10 February 2020

DP9 Ltd
100 Pall Mall
London SW1Y 5NQ

**PROPOSED GREAT WOLF LODGE, LAND TO THE EAST OF M40 AND SOUTH OF A4095, CHESTERTON, BICESTER.
CDC REFERENCE: 19/02550/F**

Title:  
Proposed Access Arrangement

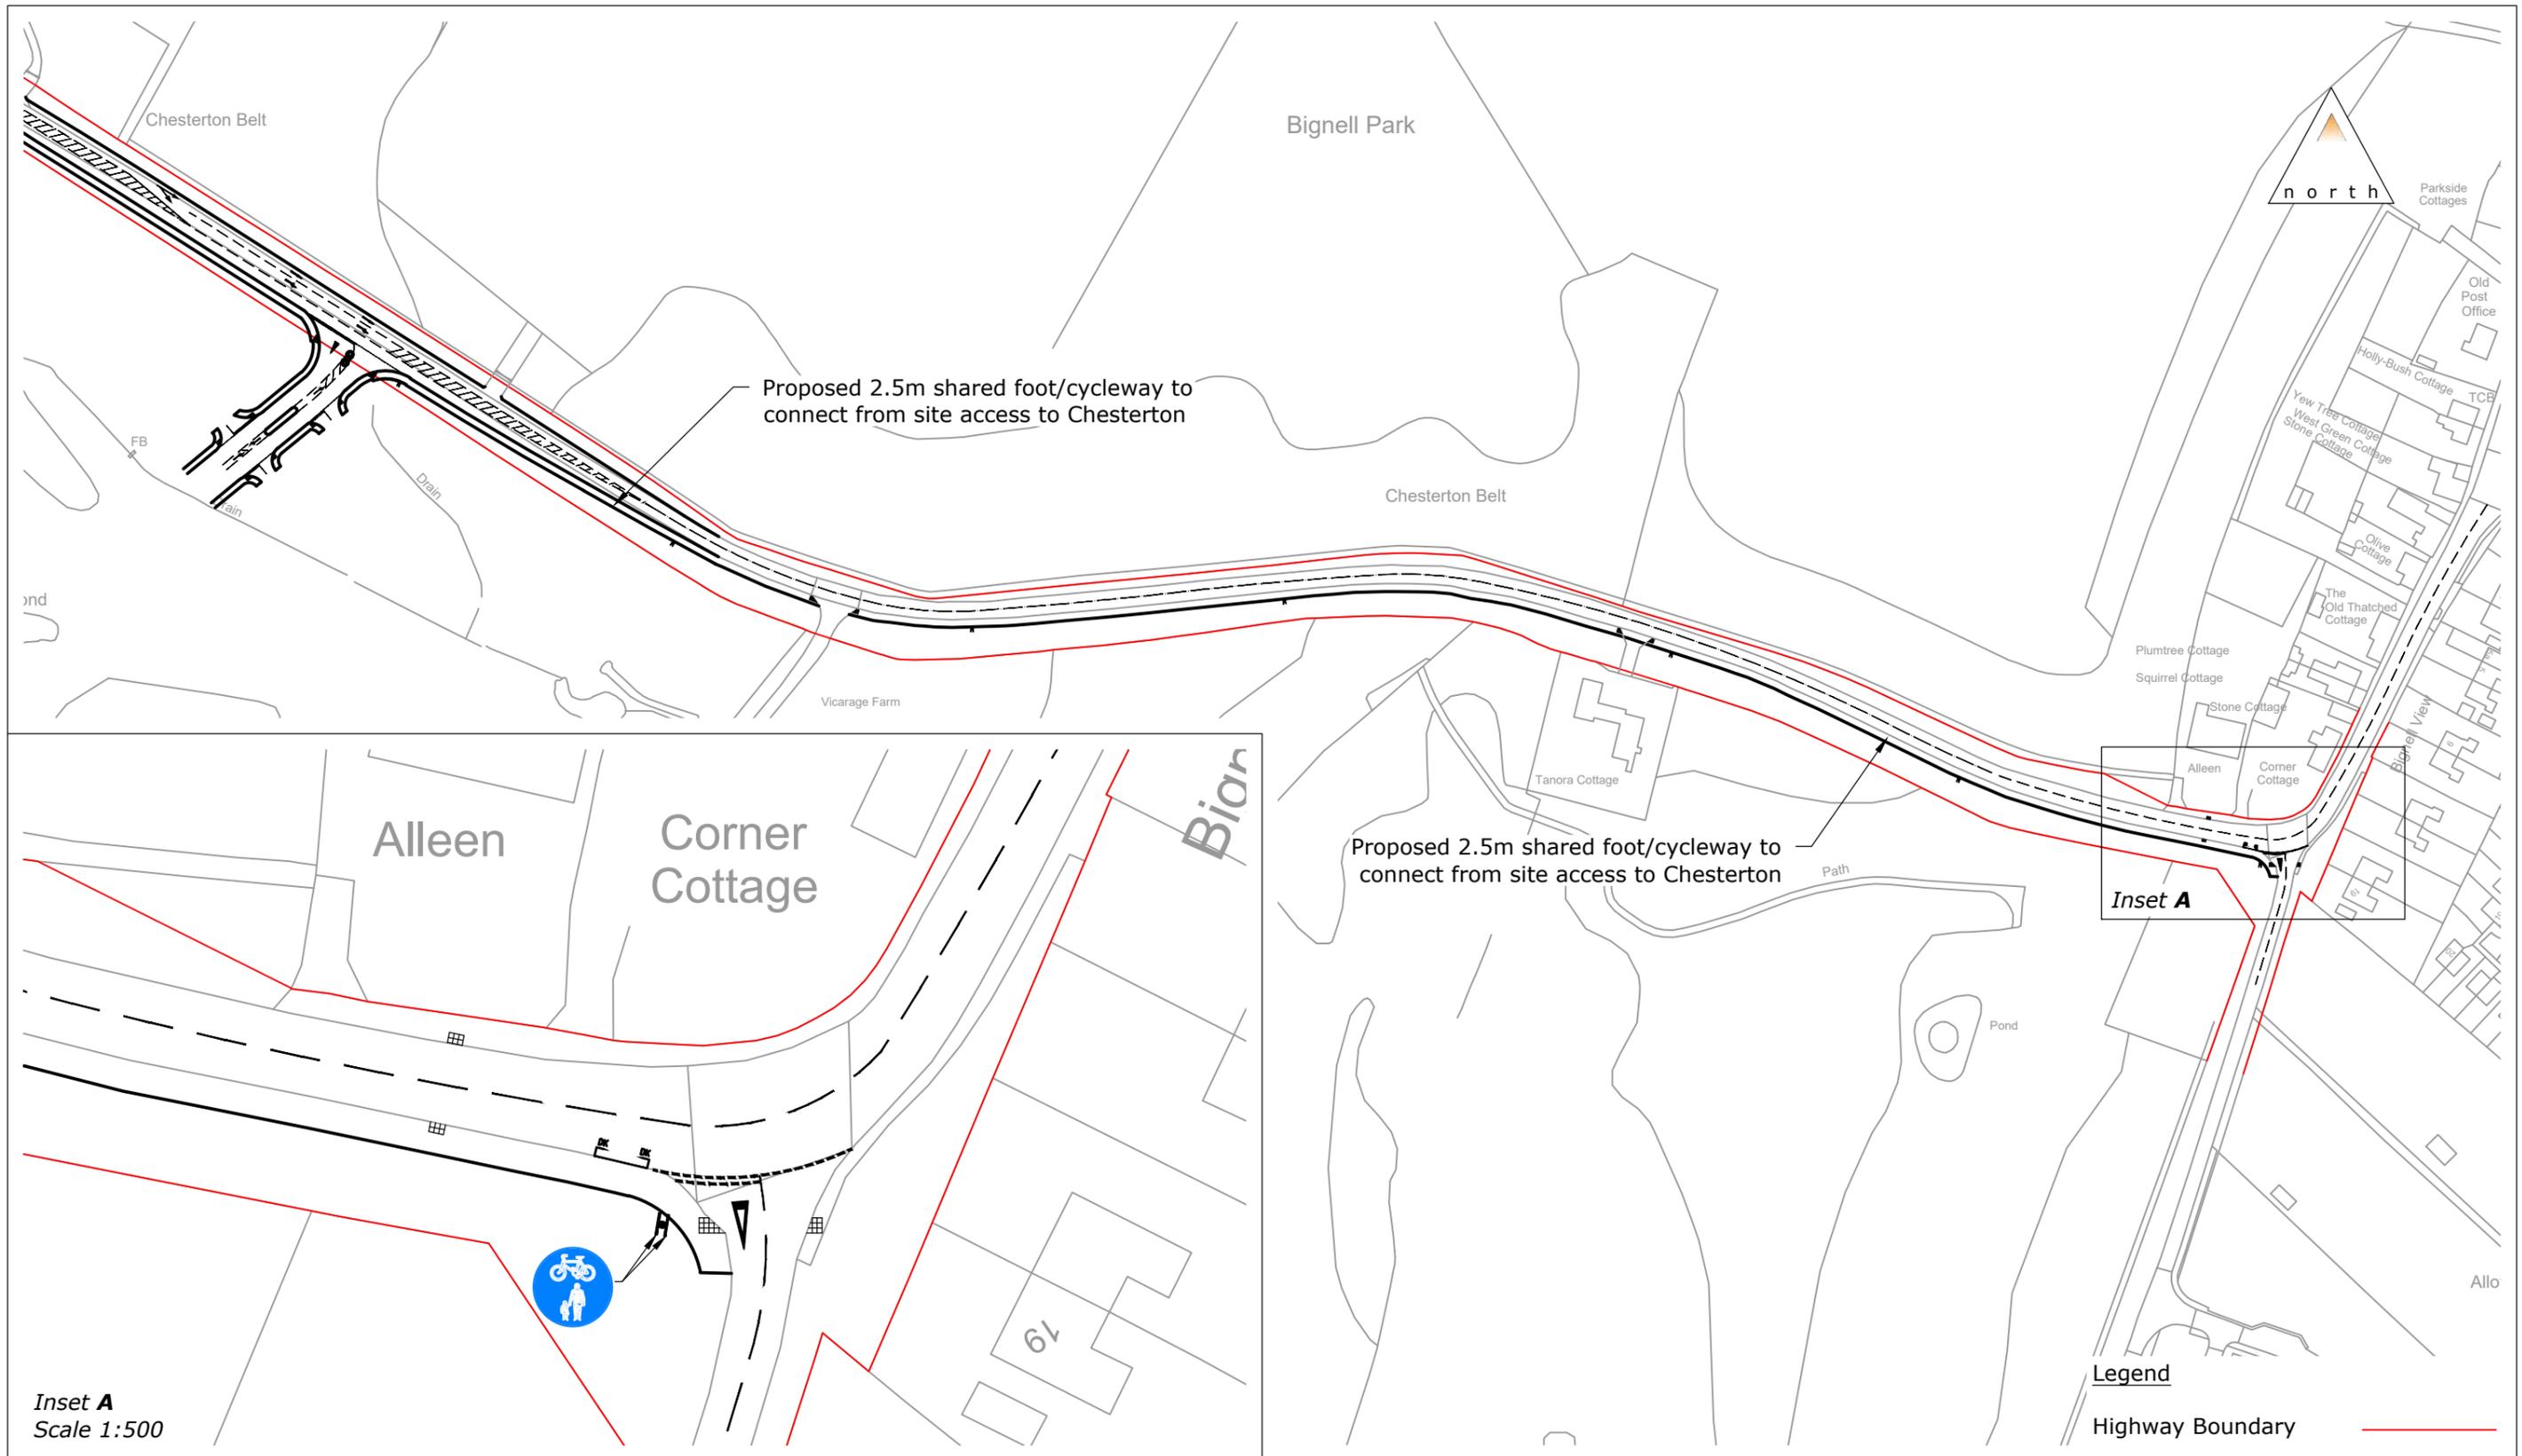
- The PBA work refers to the design of the proposed site access junction. The junction has been designed with reference to the Design Manual for Roads and Bridges and scaled plans were provided as part of the Transport Assessment which allow geometries of the junction to be measured. Oxfordshire County Council ('OCC') officers have reviewed the design of the site access junction and are satisfied with the layout proposed. It is not a requirement of OCC to provide a road safety audit at the planning stage and OCC have not requested an audit. However, Motion have confirmed that this could be prepared if it is considered beneficial. The Transport Assessment includes junction capacity modelling based on the proposed geometries and this demonstrates that the junction will operate within capacity during all peak periods and the proposed right turning lane is sufficient to accommodate vehicle turning right into the site and there would be negligible queuing or vehicle delay.

Title:  
Proposed Shared Foot/Cycleway

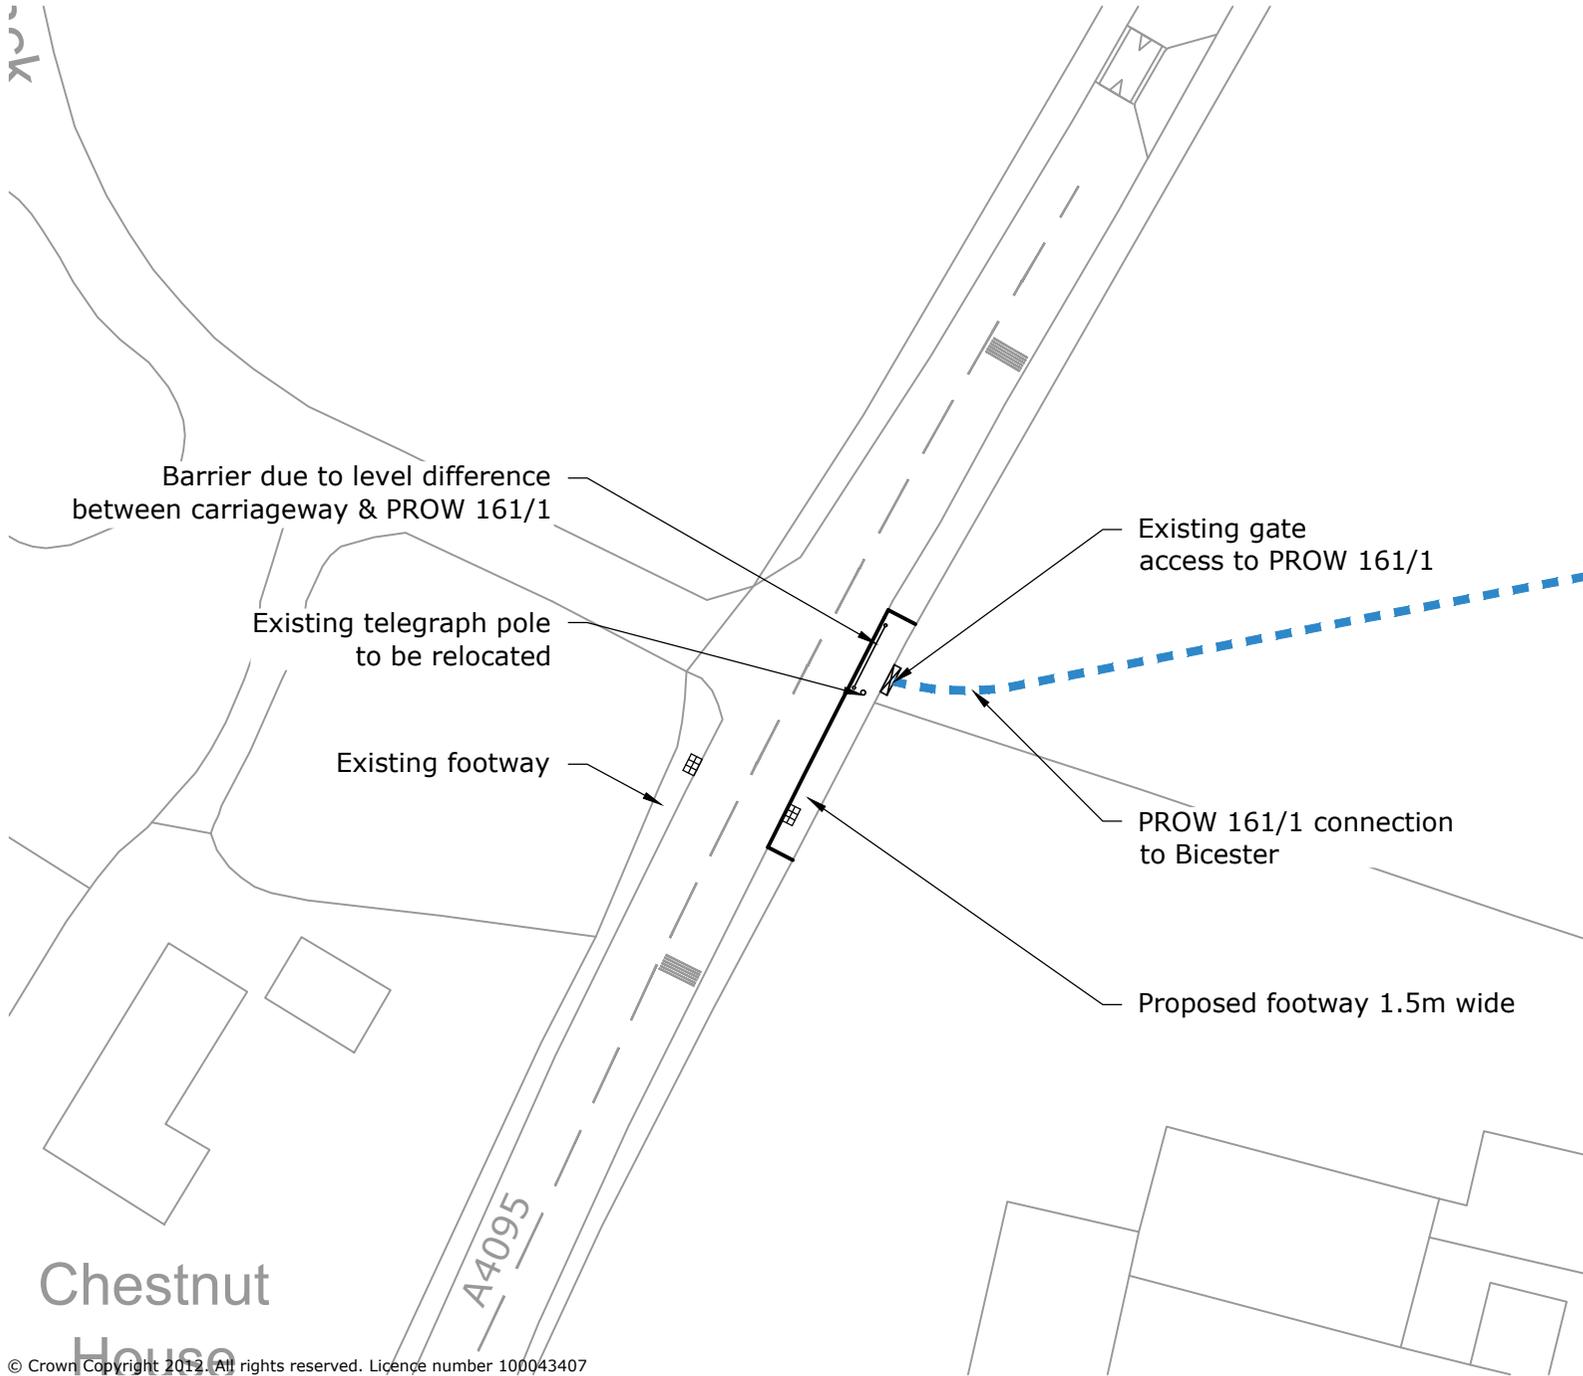
- The PBA work also suggests that plans of highway works lack detail of corduroy paving (tactile paving). This is incorrect as Drawings 1803047-02 and 1803047-03, show the detail of tactile paving on the proposed footway route from the site in to Chesterton village. Full details of all tactile paving and dropped kerbs etc. would be provided at the detailed design stage. It is also noted that OCC have raised no concern in this regard.
